WEST SUSSEX COUNTY COUNCIL CONSULTATION

TO:	Arun District Council FAO: Mrs A Gardner
FROM:	Highways, WSCC
DATE:	25/09/2018
LOCATION:	134, Elmer Road, Middleton On Sea, PO22 6HZ
SUBJECT:	M/101/18 Demolition of existing dwelling & erection 1 No. holiday home.
DATE OF SITE VISIT:	N/A
RECOMMENDATION:	☒ Advice ☐ Objection ☐ Modification ☐ No Objection ☐ More Information ☐ Refusal
S106 CONTRIBUTION TOTAL:	£N/A

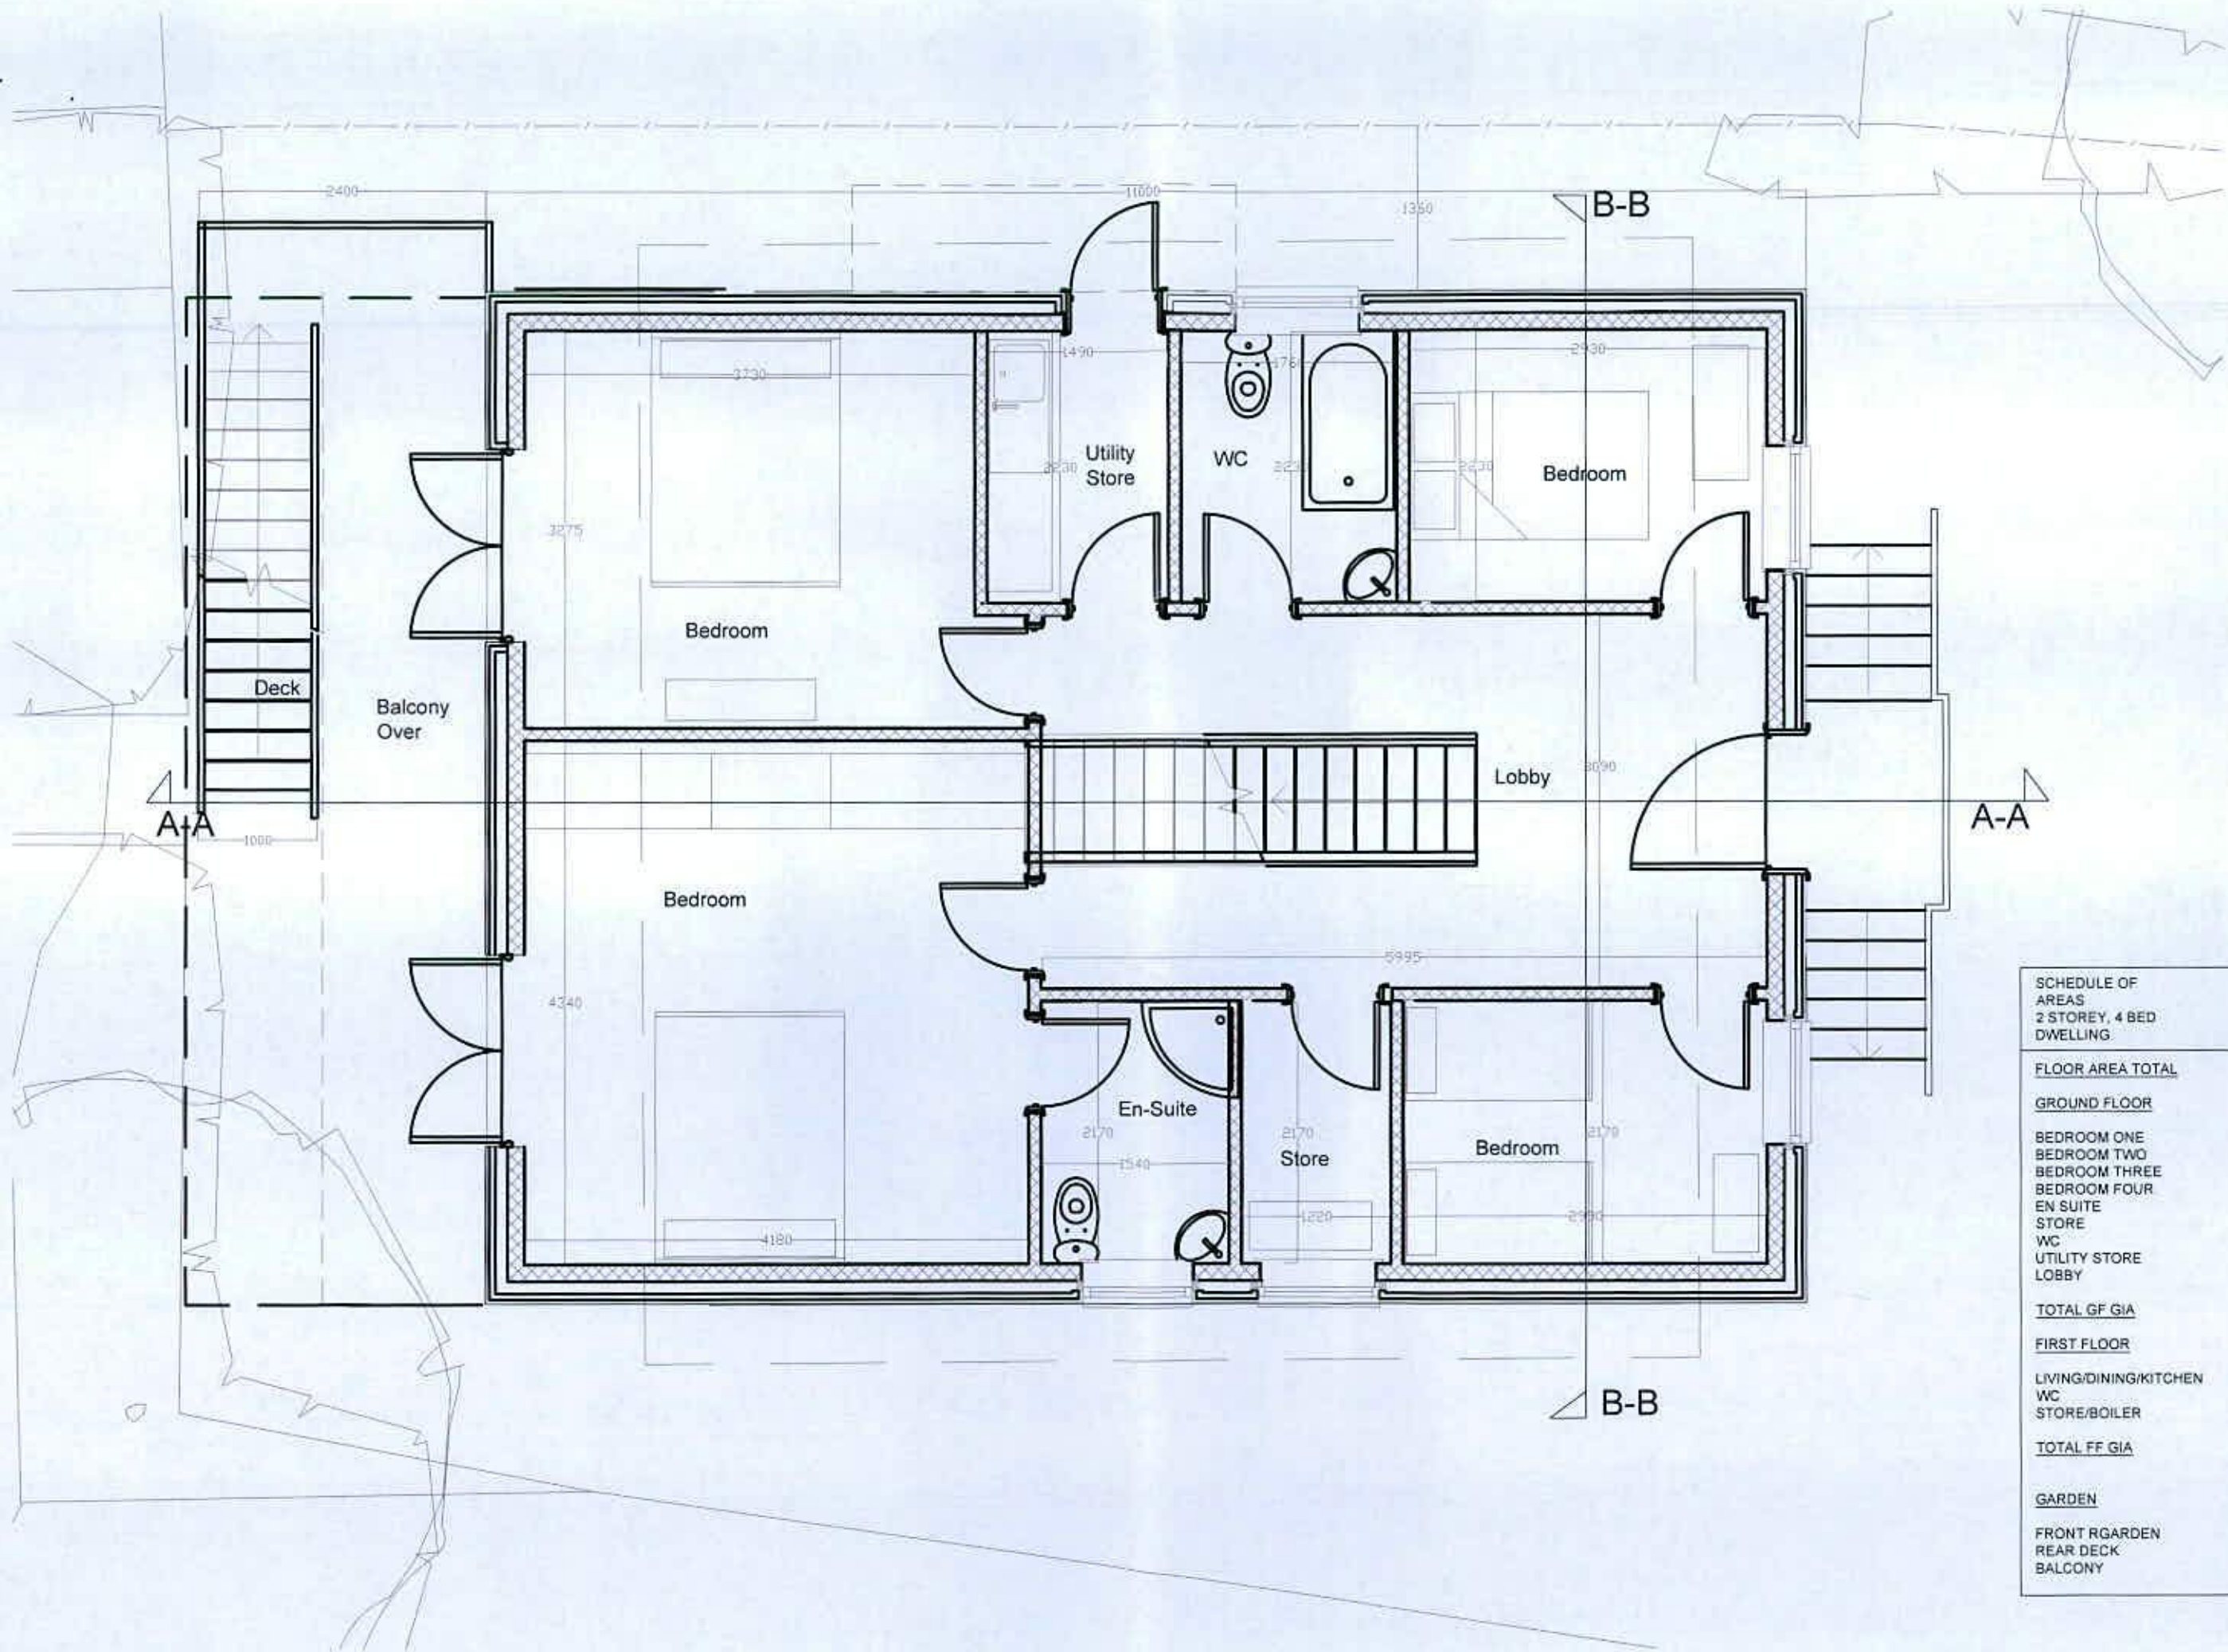
The proposed plans demonstrate that two parking spaces will be provided for the replacement dwelling. The WSCC car parking demand calculator expects that this is a sufficient parking provision for a dwelling of this size and location. The proposed parking spaces meet the specifications of 2.4 x 4.8m as set out in Manual for Streets (MfS). A turn on site has not been demonstrated although there appears to be sufficient space for vehicles to turn on site and exit onto the public highway in a forward gear. The applicant has not provided details of secure and covered cycle storage – details of this can be secured via condition.

No part of the development shall be first occupied until the car parking has been constructed in accordance with the approved site plan. These spaces shall thereafter be retained at all times for their designated purpose.
